RE WORTLEY VILLAGE PLAN

Following our site meeting at Wortley Village on 20th October 2016. Please find attached the following drawings revised as per our onsite discussions.

707 07-03 P1

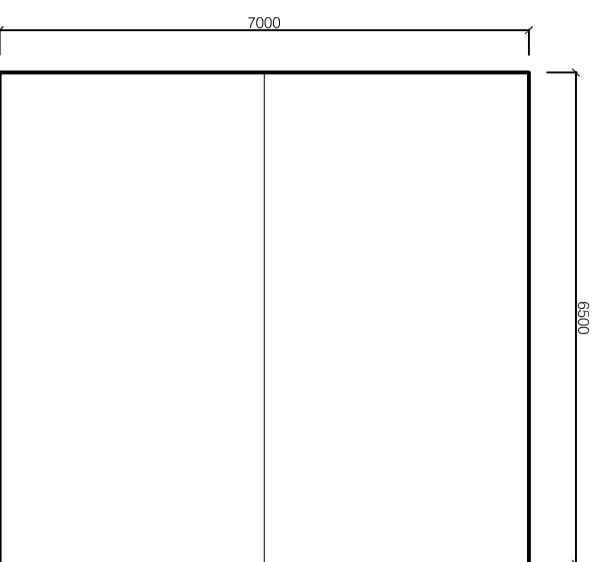
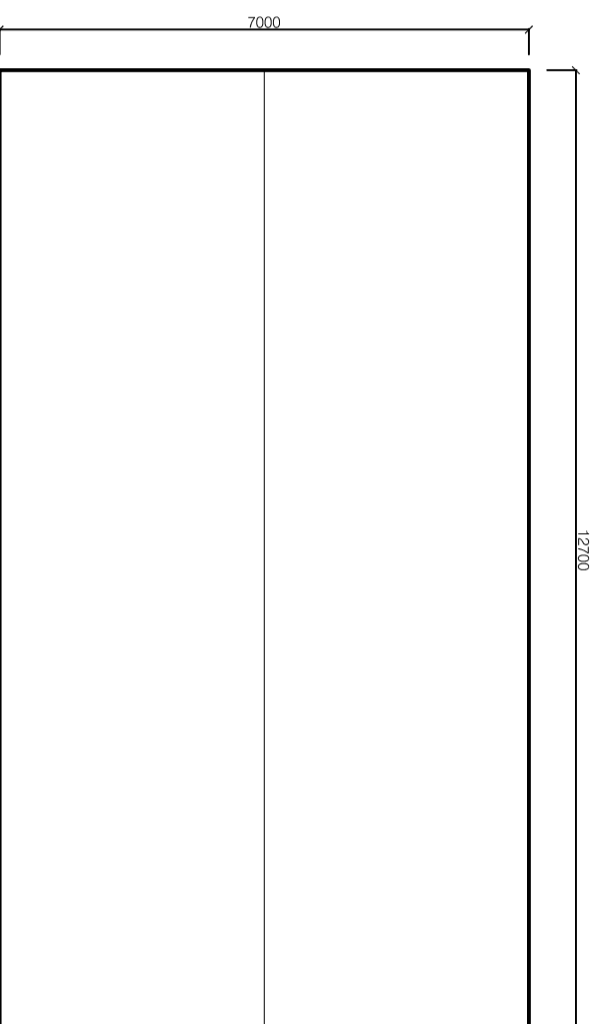
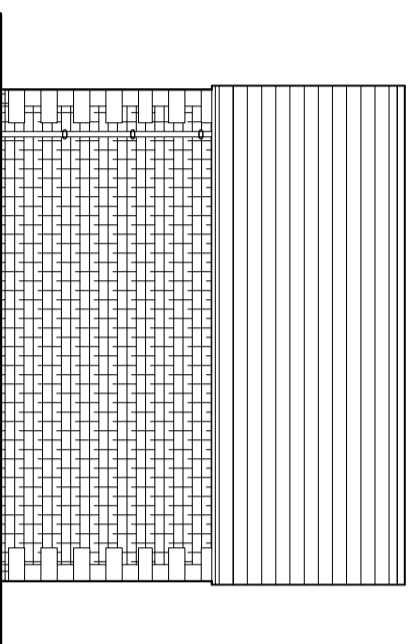
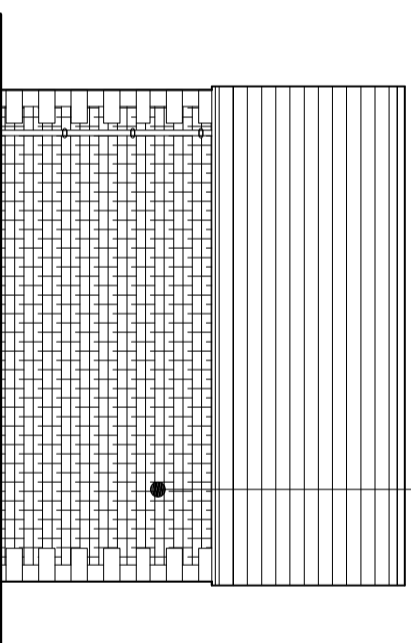
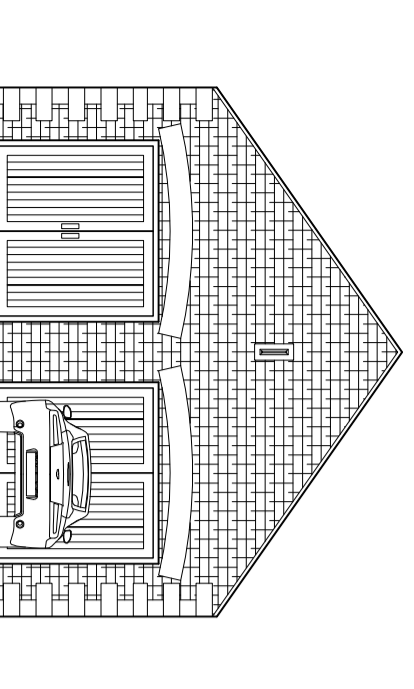
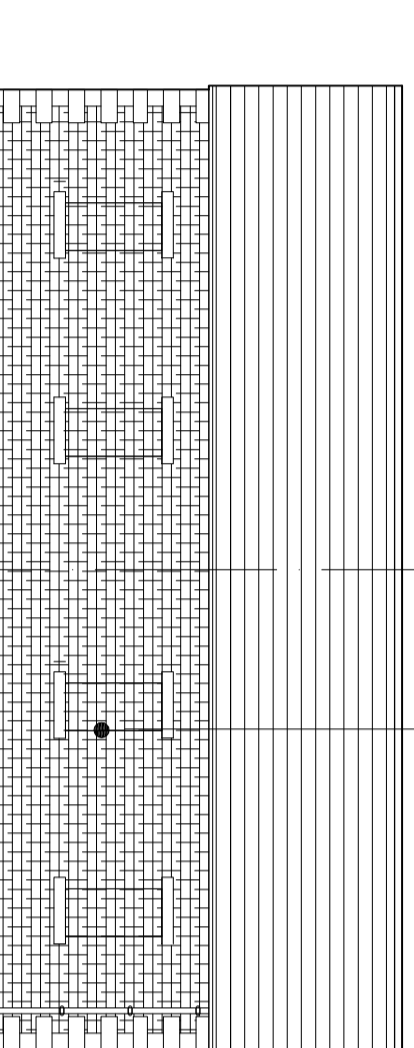
- 707-07-03-P1** Gutter details added. roof detail amended to include stone courses below slate as localised detail.
- 707-08-01-P2** General arrangement of houses amended to reduce proximity to neighbours at rear

707 08-02

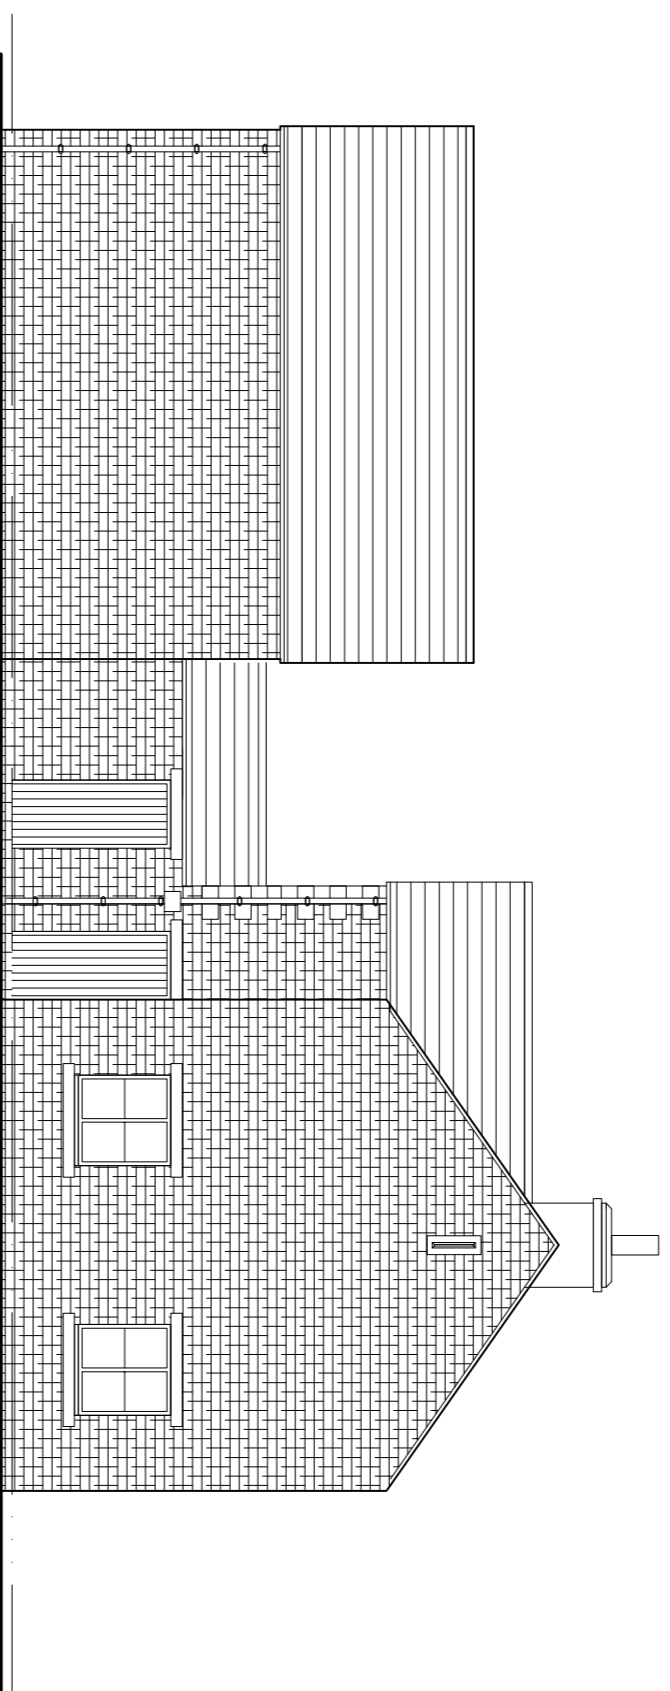
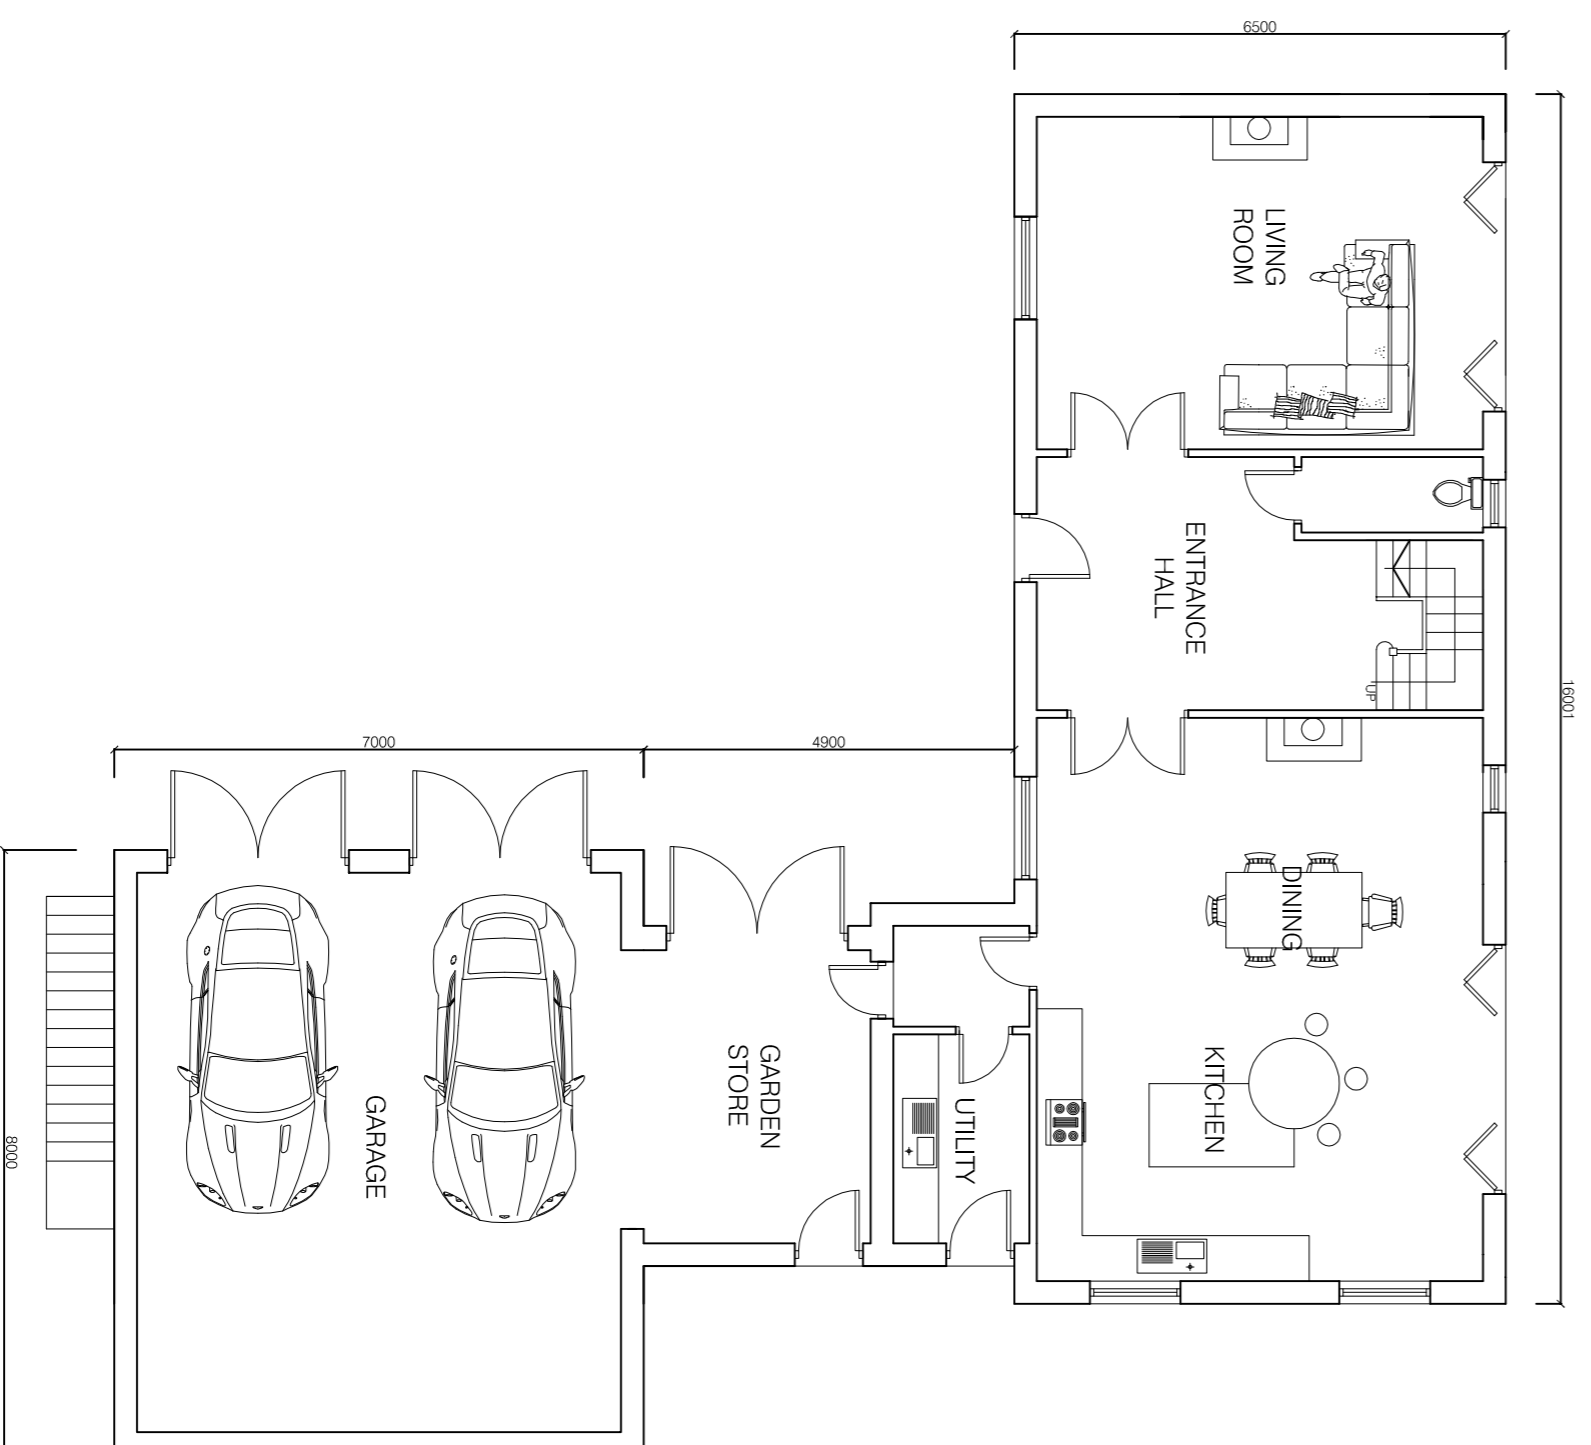
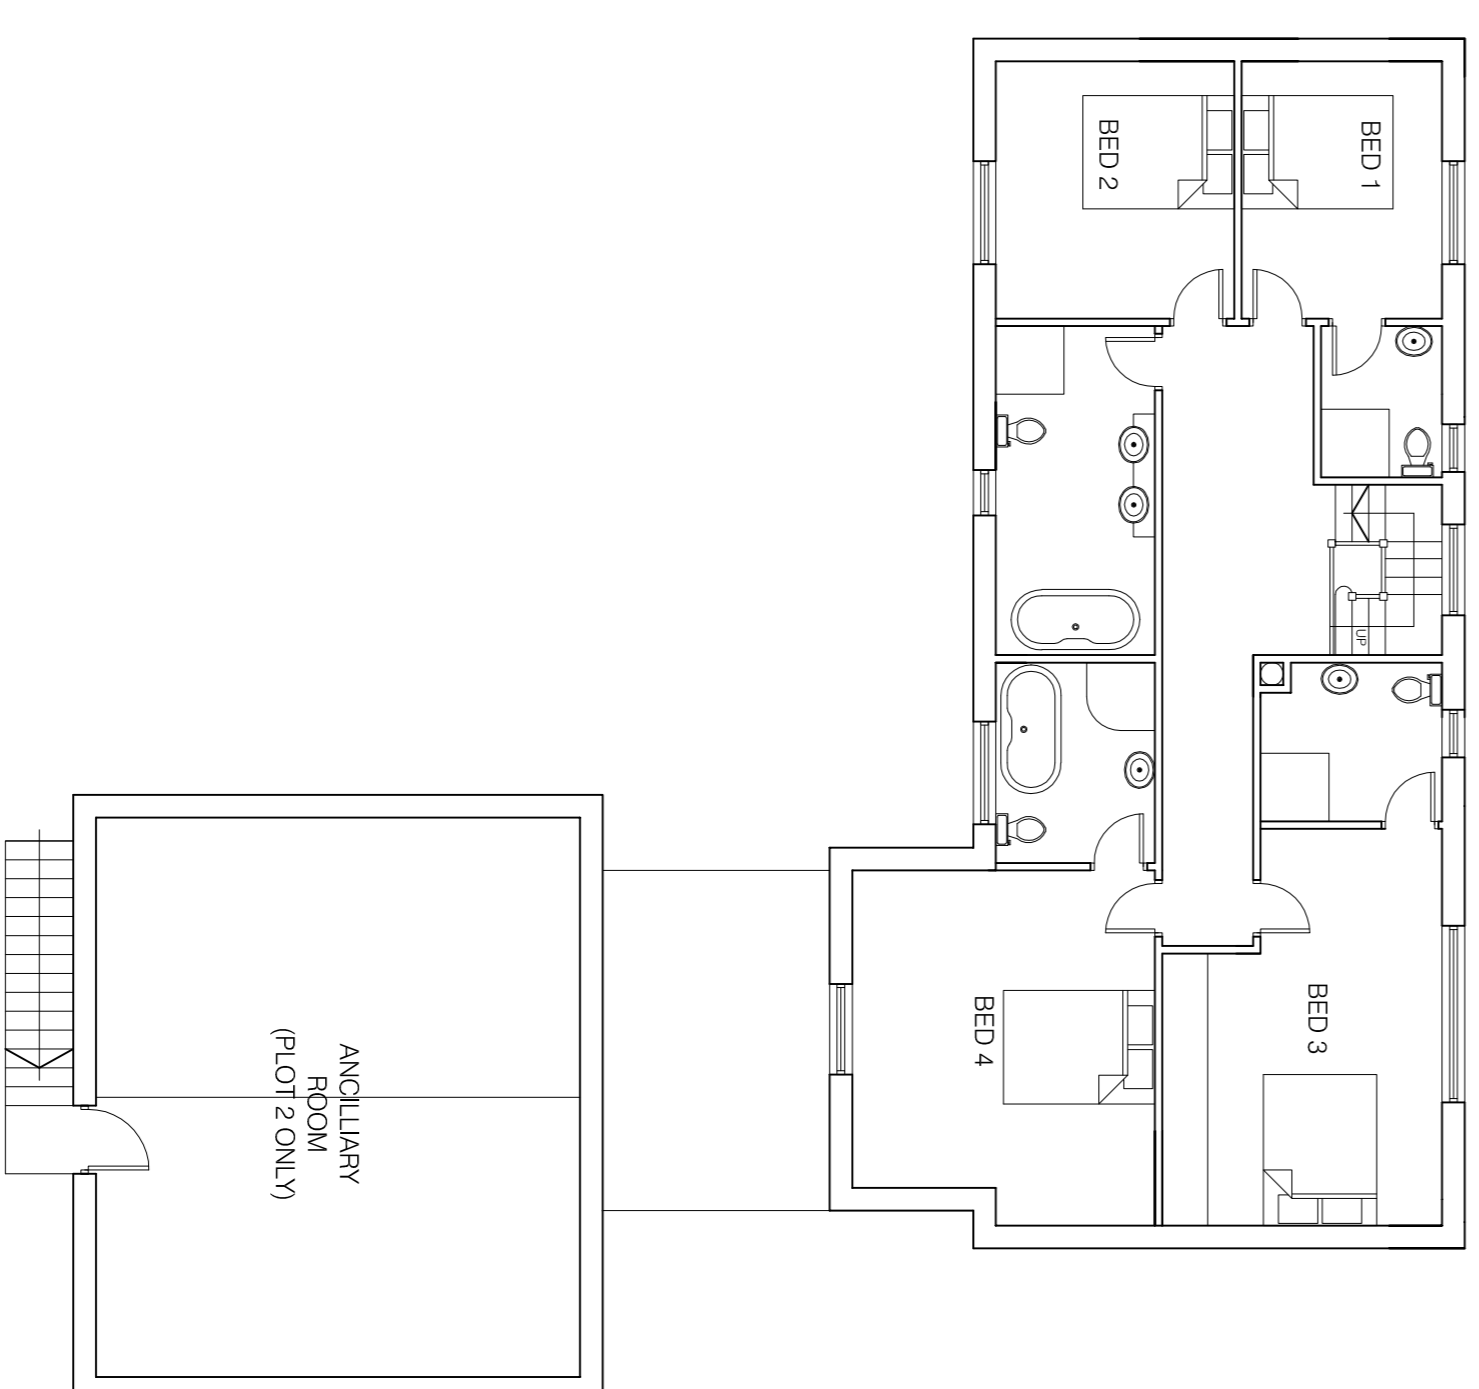
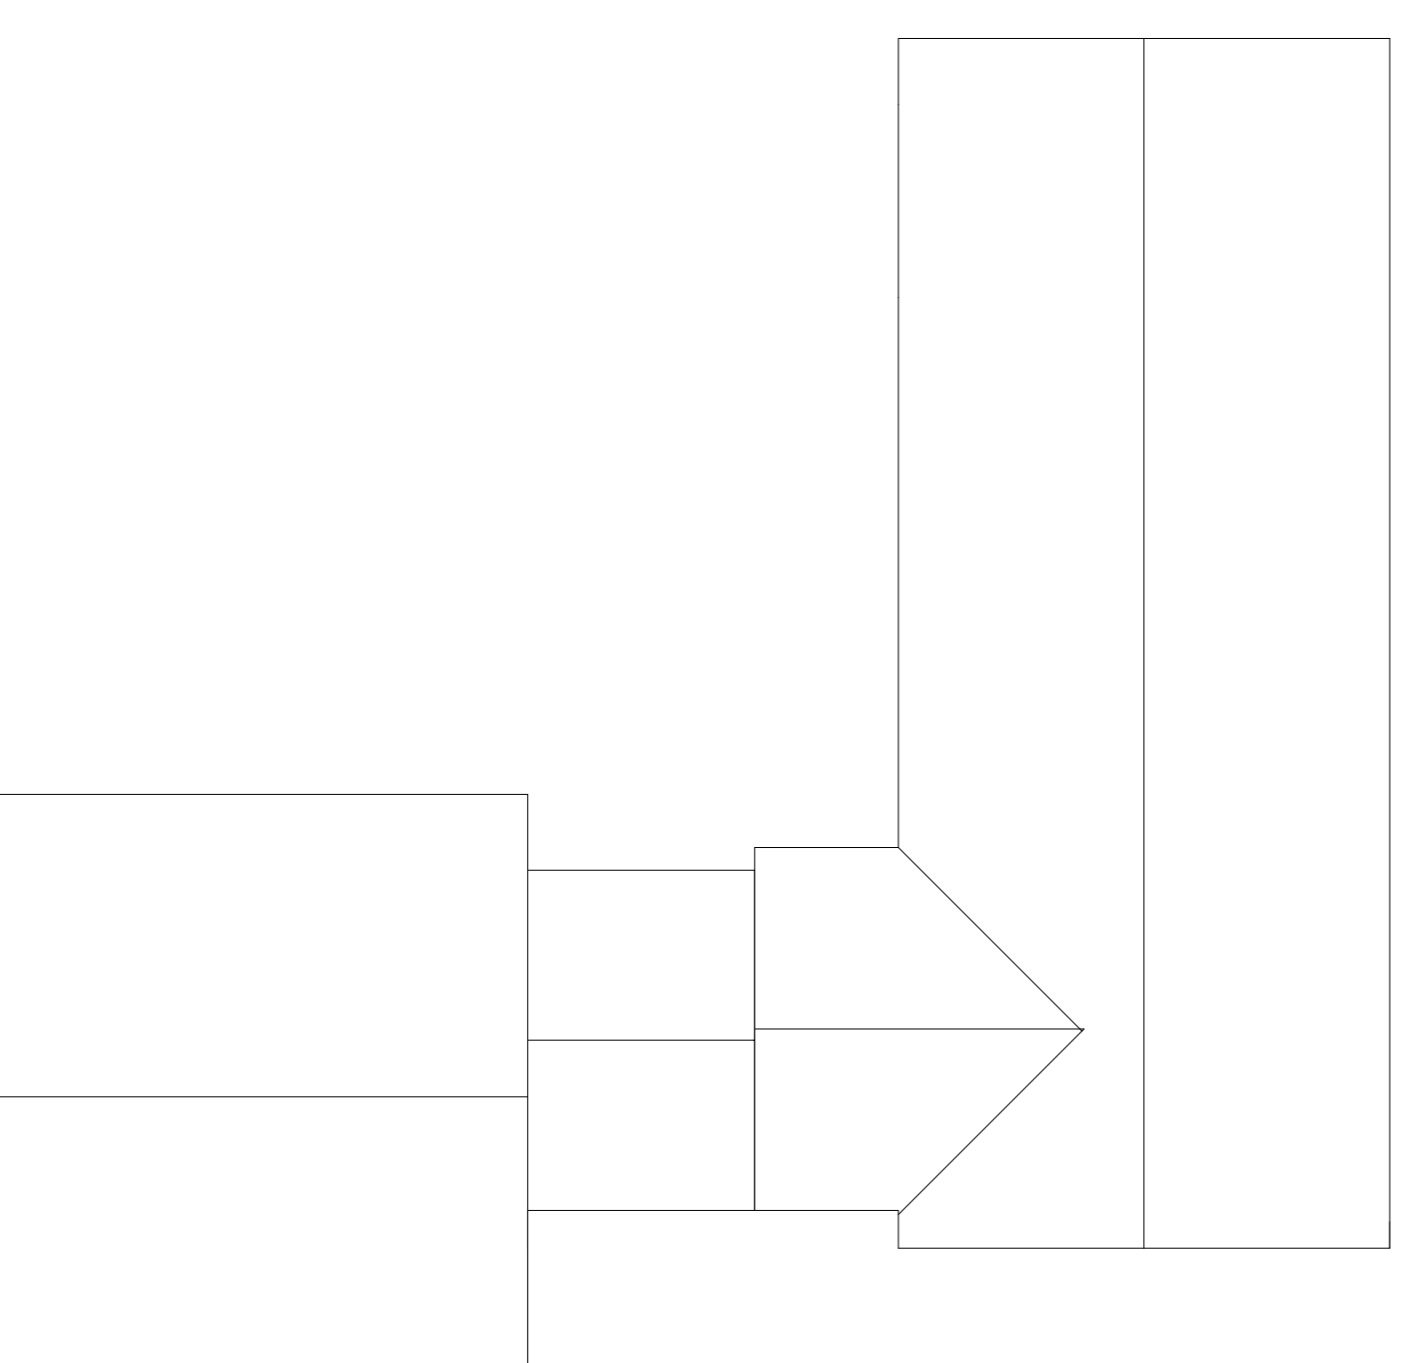
- 707-08-02-P1** Plans and elevations amended to reduce proximity to neighbours and provide difference in appearance of plots 1 & 2
- 707-08-03-P1** Elevations & sections amended to show alternative approach to elevations of plots 1&2
